From: Simon Davis
Sent: 03 February 2021 12:50
To: Planning Scanning
Subject: FW: BR/8/21/RES

From: Simon Davis <Simon.Davis@arun.gov.uk>
Sent: Wednesday, February 3, 2021 12:36 PM
To: Richard Stefanski [REDACTED]
Subject: BR/8/21/RES

With reference to Environmental Health's comments on the original application (BR/142/18/OUT), Environmental Health objects to this application as the layout has habitable rooms facing the railway which will mean that BS8233 will only be met if the windows are kept closed. This application therefore does not follow the principles of good acoustic design within ProPG.

Drawing Title:
PROPOSED FLOOR PLANS

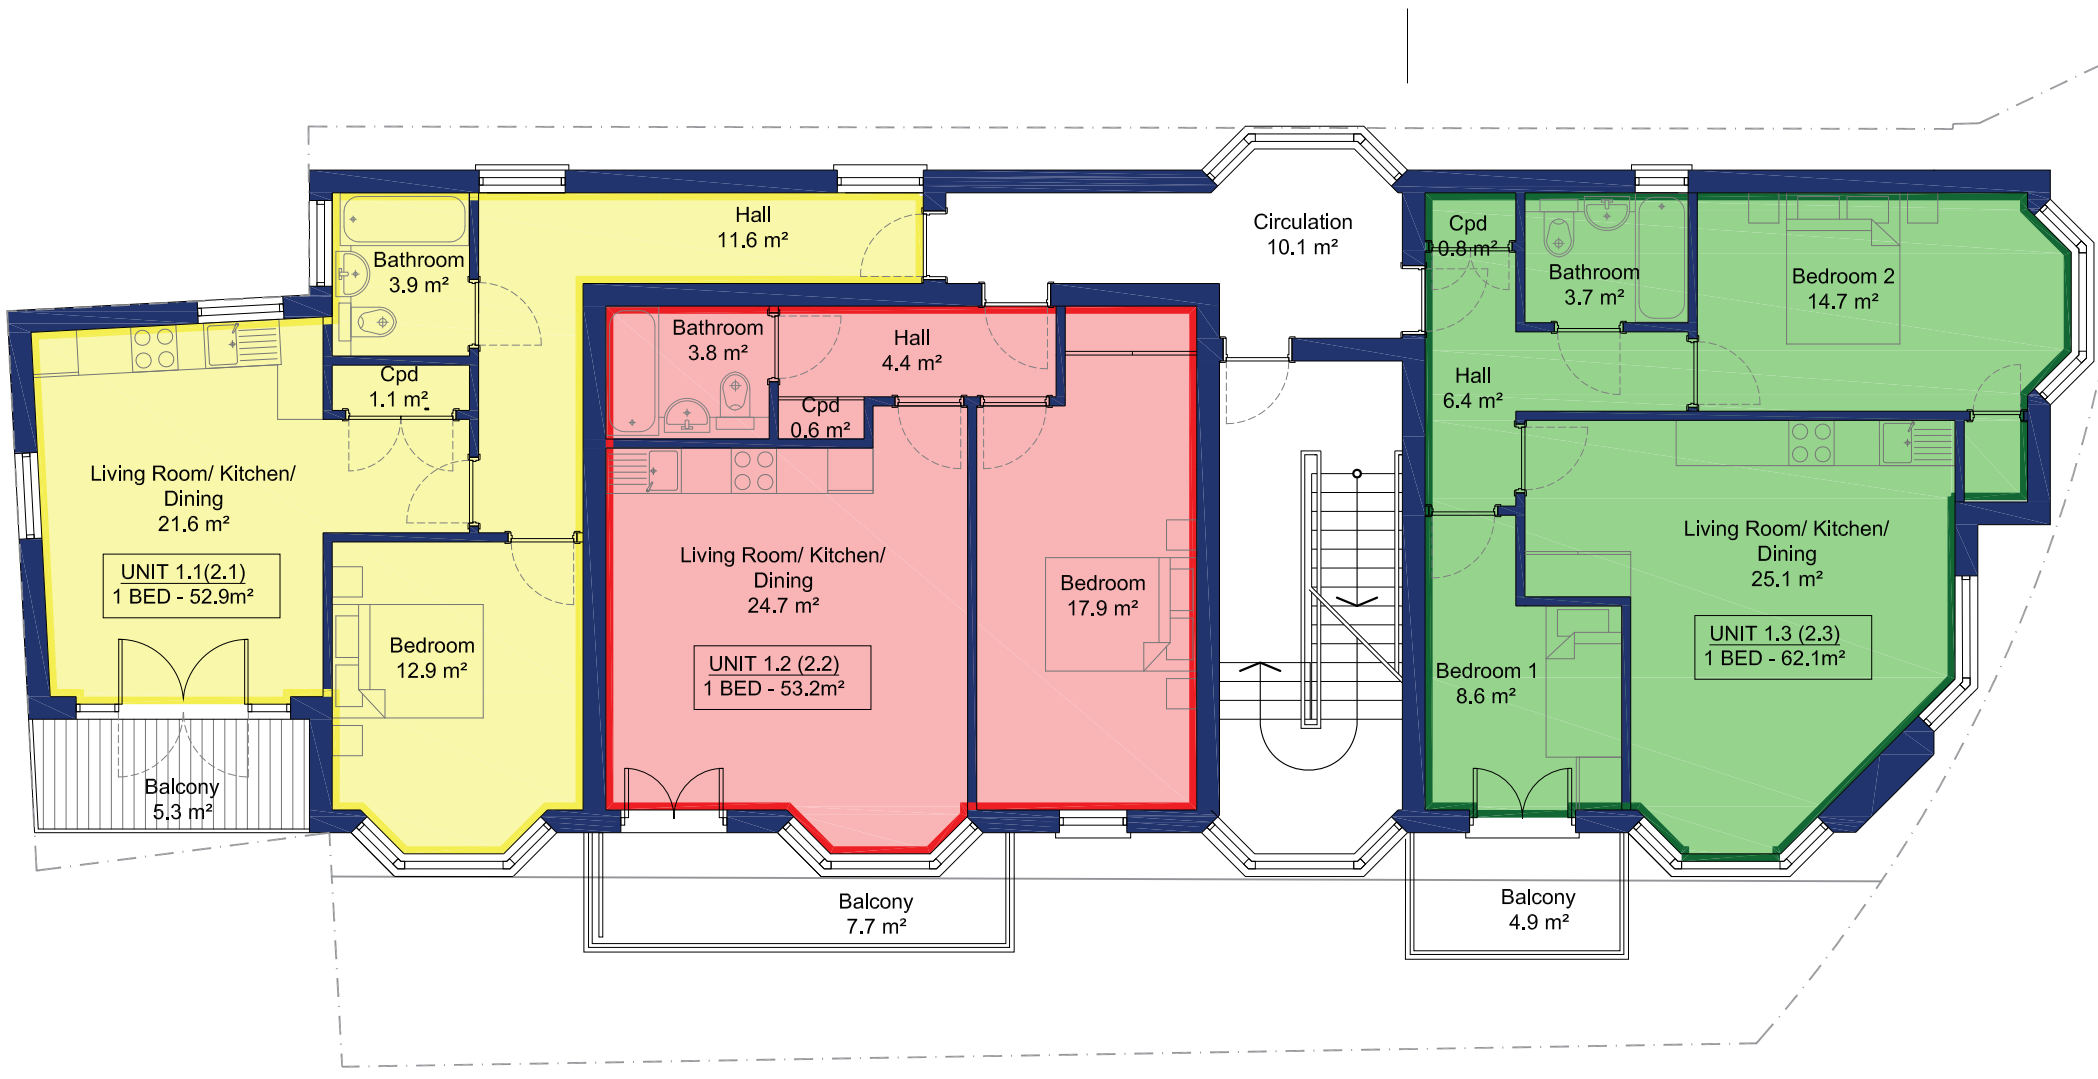
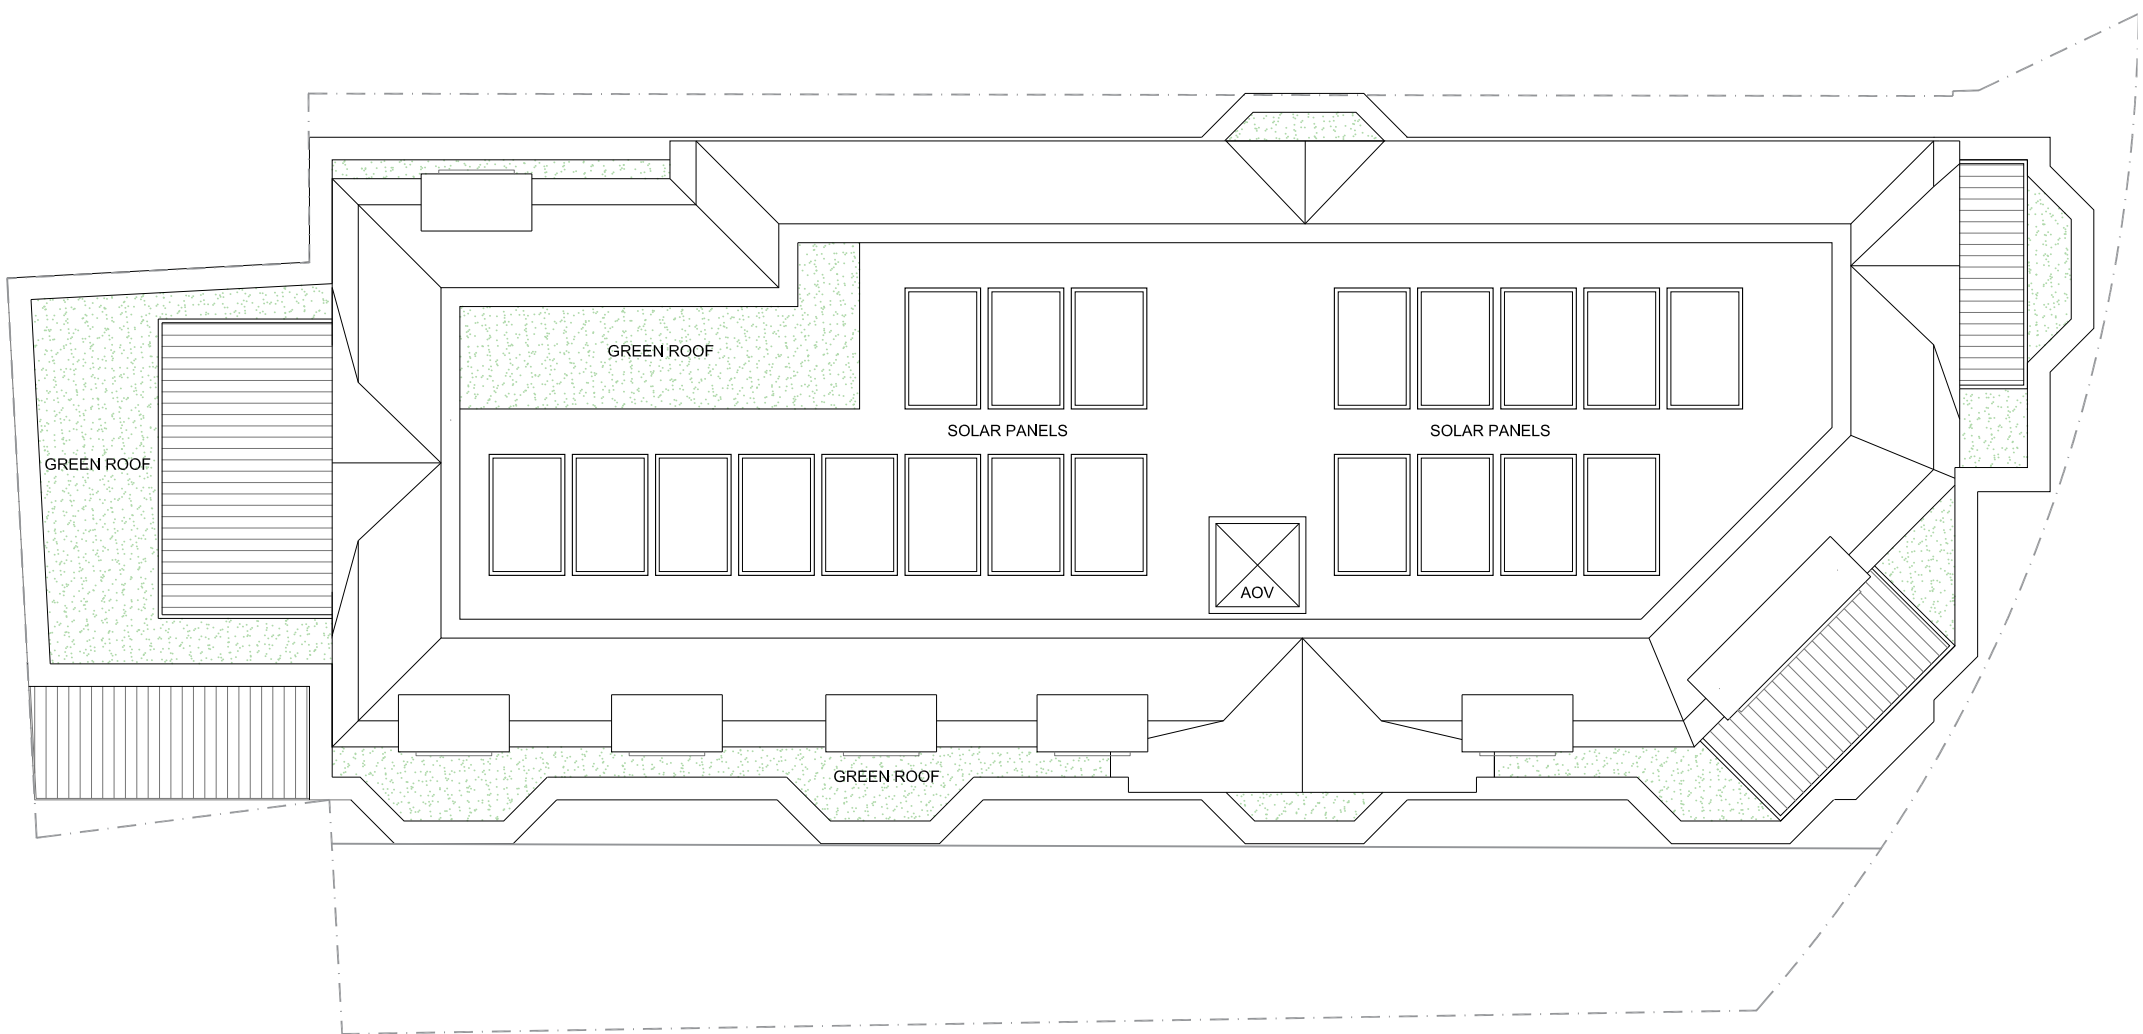
Please note that this was raised at the outline stage and indeed formed part of an informative 12 on the decision notice. I therefore write to request that you amend the floor plans/building layout to remove habitable rooms from the elevation backing onto the railway line. Please provide amended plans by the 17th February or if you need longer, advise me when you need until.

We will provide updated plans next week.
